Our Ref: HB/LambsClose/2016/REV  
Your Ref: 6/2015/2173/FULL  
Date: 18 February 2016

**APPLICATION NO:** 6/2015/2173/FULL

**SITE AT:** Land adjacent to flats 37 to 48 Lambs Close, Cuffley, Hertfordshire EN6 4HD

**PROPOSAL:** Erection of 2 no. 2 bedroom flats together with associated parking and retention of existing car parking spaces following demolition of existing garages.

5 Proposed Site Plan - Roof Plan
1:200

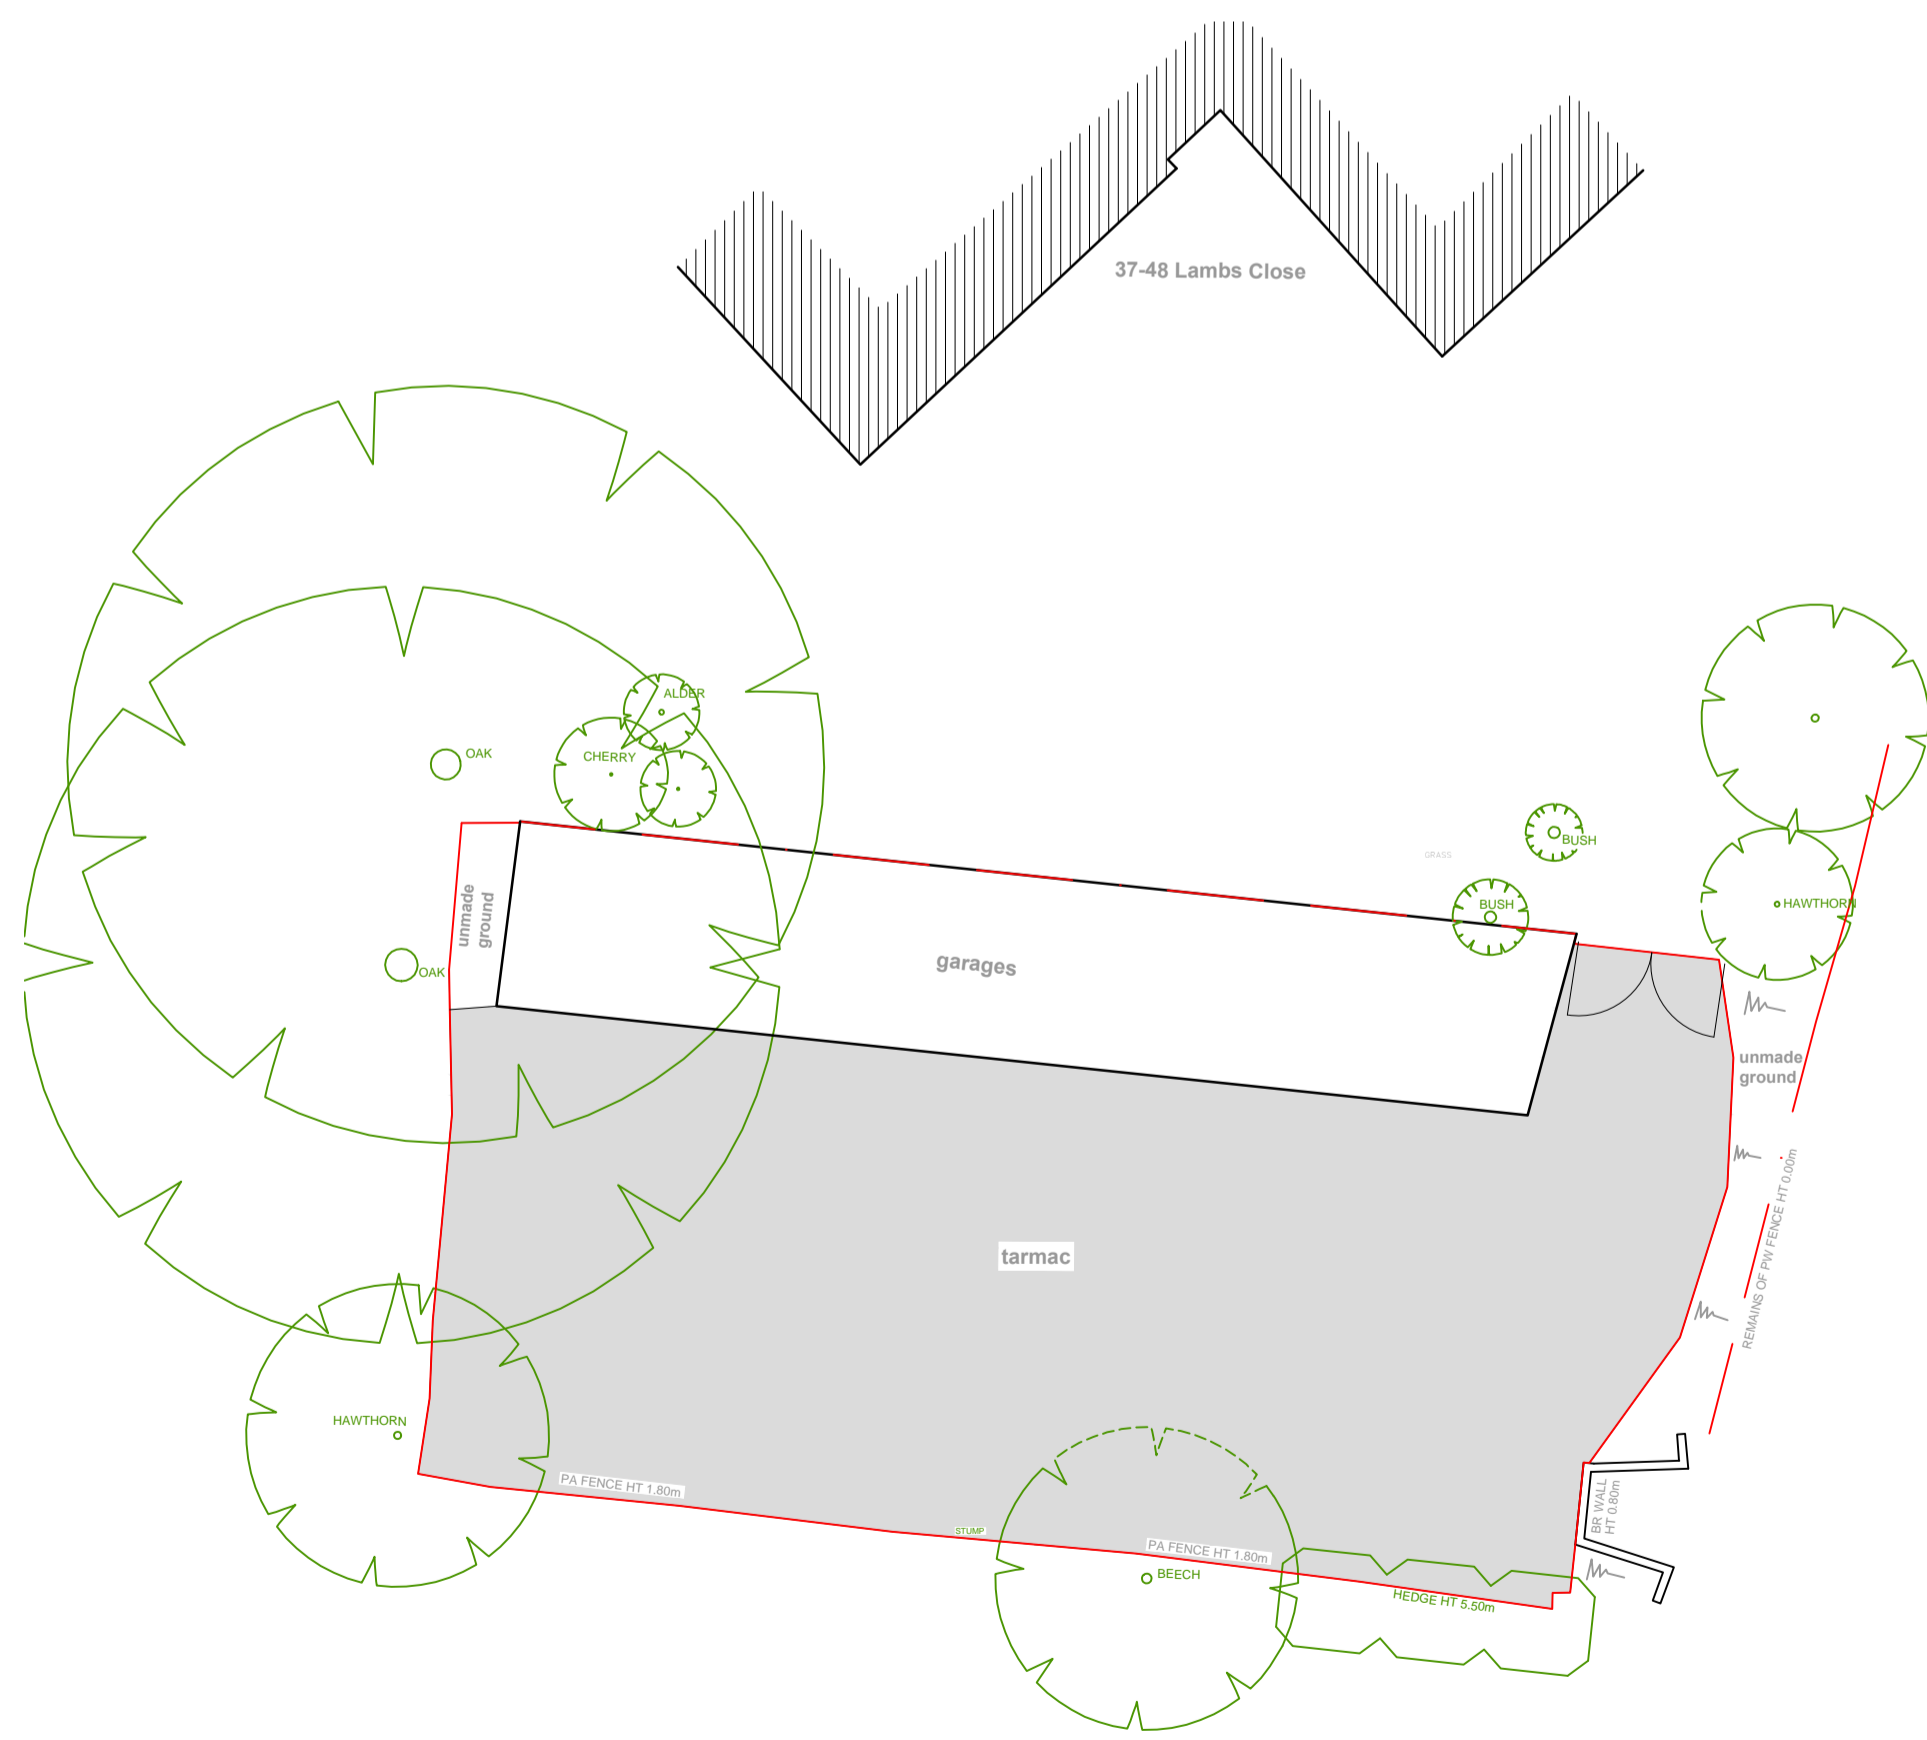
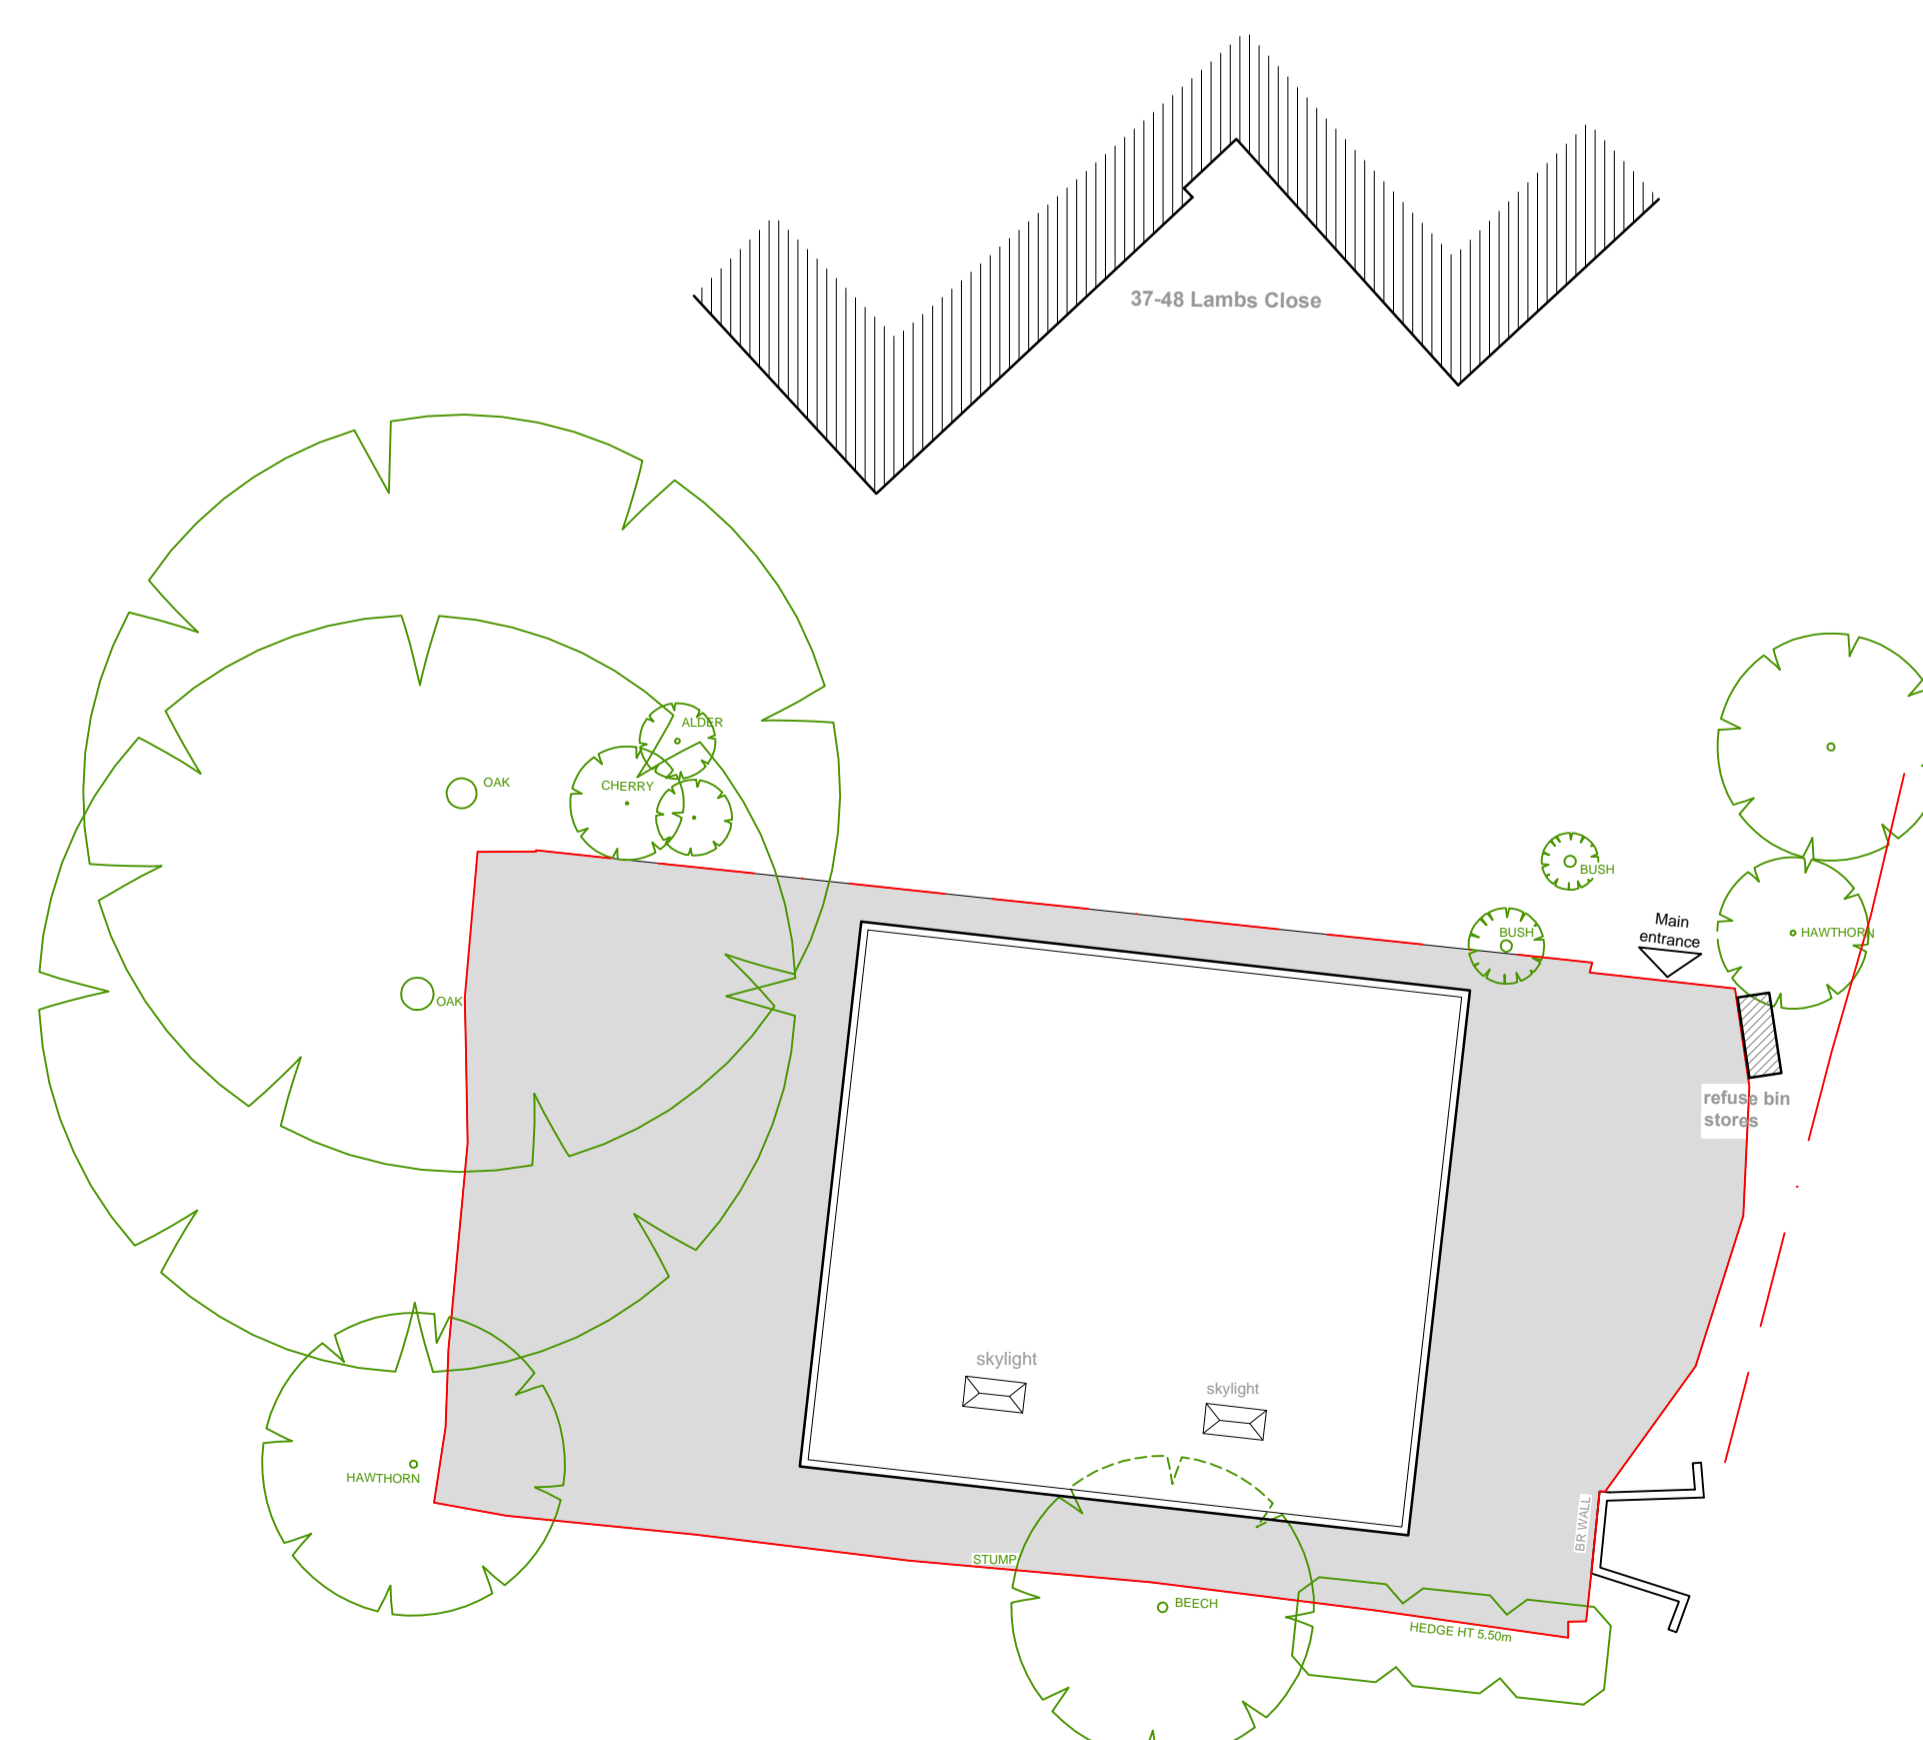
1.1 We write to comment on the amended plans to planning application 6/2015/2173/FULL, specifically drawing numbers 1139-301b rev B and 1139-301 rev B that show "additional secure cycle parking".

- 2.2 We would like to see a proposed plan of the secure cycle parking building in due course and for obvious reasons we suggest that a maintenance strip of land is incorporated around this building. As mentioned in our letter dated 7 January 2016 "The cycle parking building should be secure, perhaps accessed by key code, and adequately lit".

- 3.1 We support the revised 1139-301b rev B and 1139-301 rev B plans to provide additional secure cycle parking. Whilst writing I would also
